## Hume Coal Project (SSD 7172) and related Berrima Rail Project (SSD 7171) Notice of Exhibition

Thank you for your email 31 March 2017 requesting Transport for NSW (TfNSW) comment on the notice of exhibition of the subject State Significant Developments (SSD 7171 & 7172).

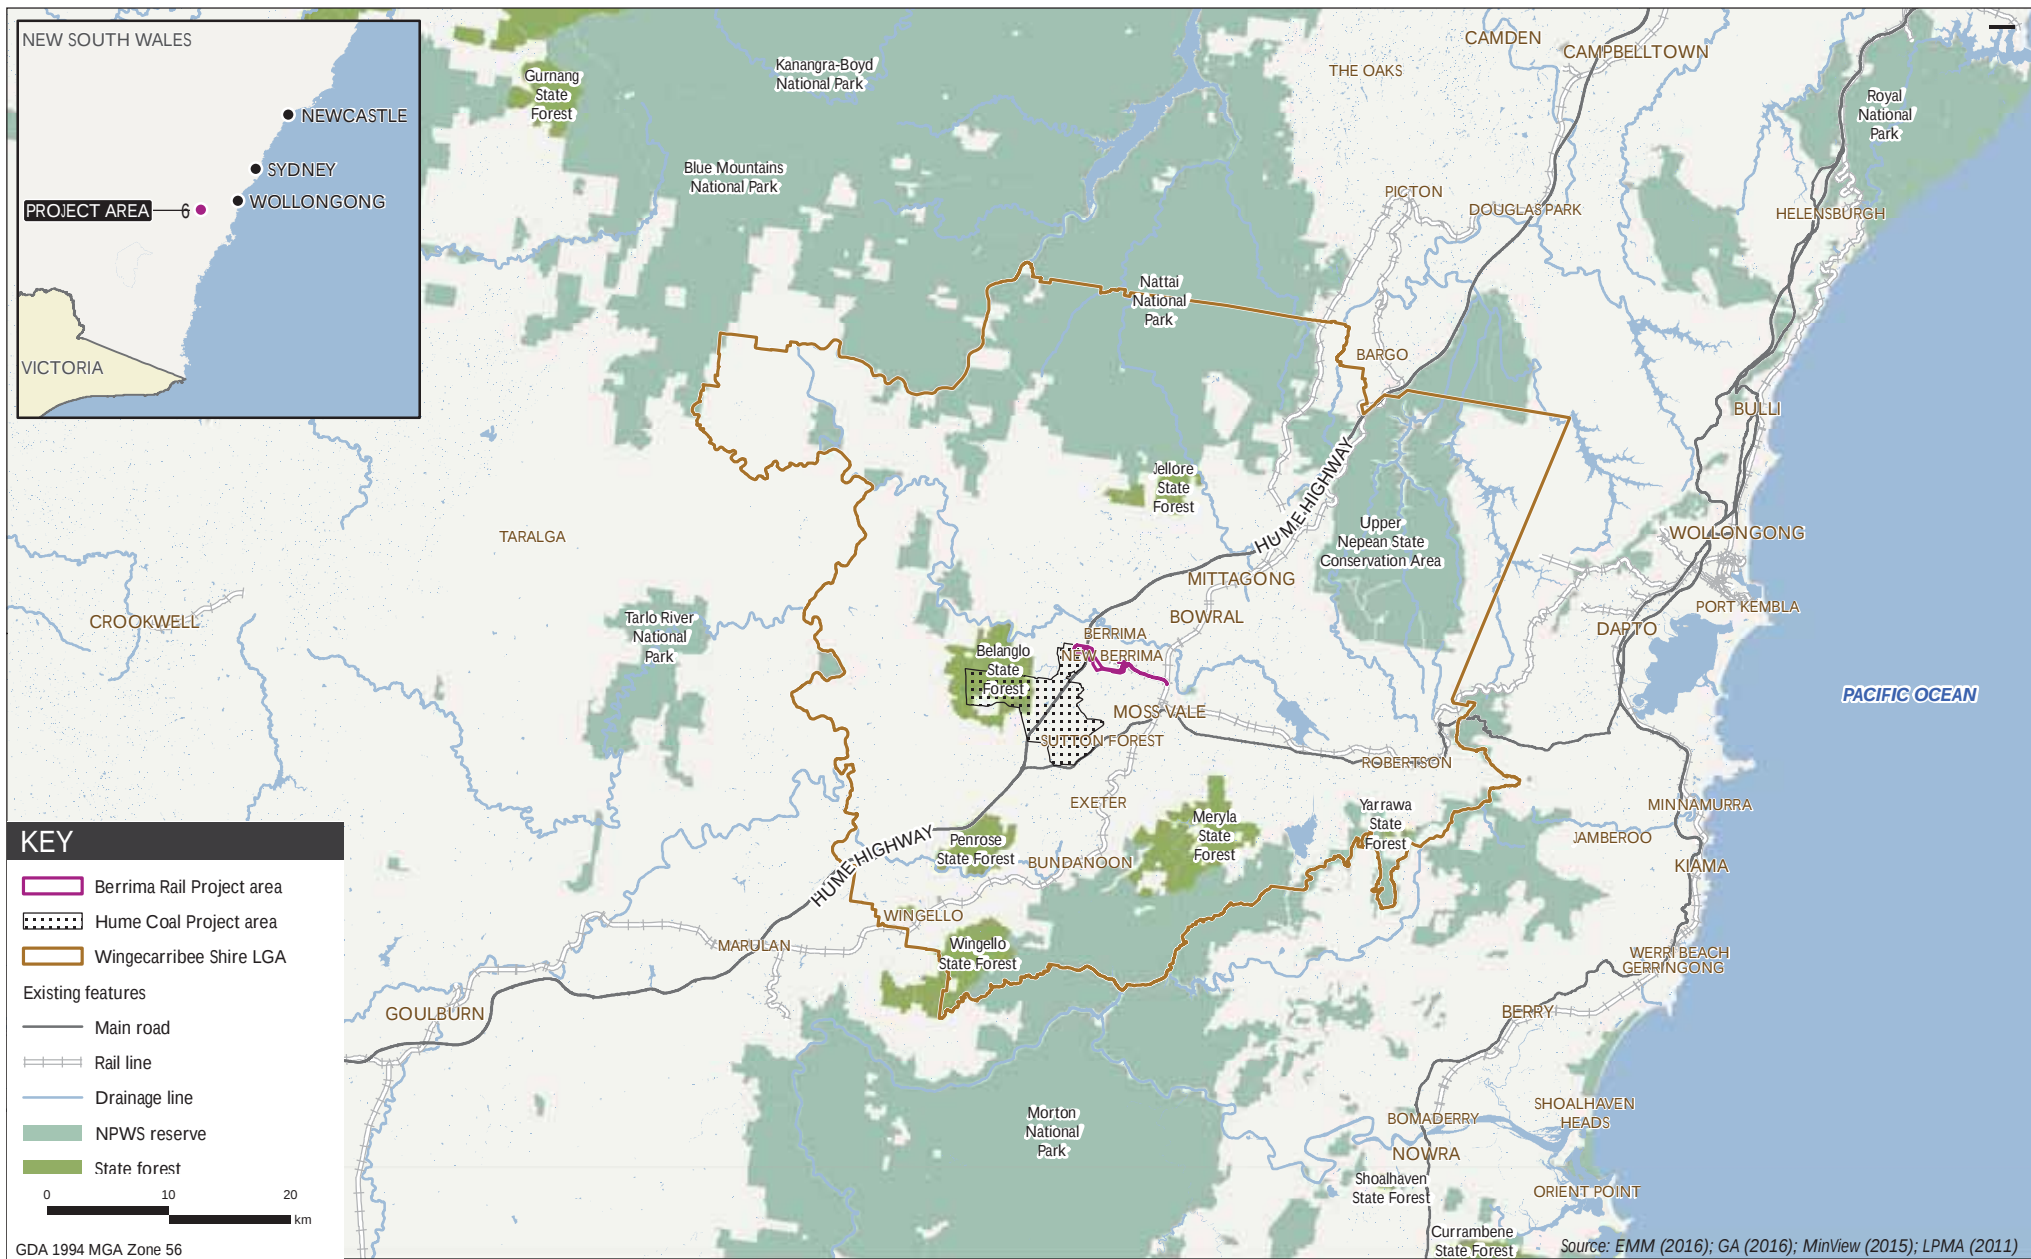
Detailed designs need to be undertaken for the proposed railway bridges over the Old Hume Highway and Berrima Road. These bridges need to be designed to provide adequate clearance and capacity as both these roads are 4.6m high HML B-double routes.
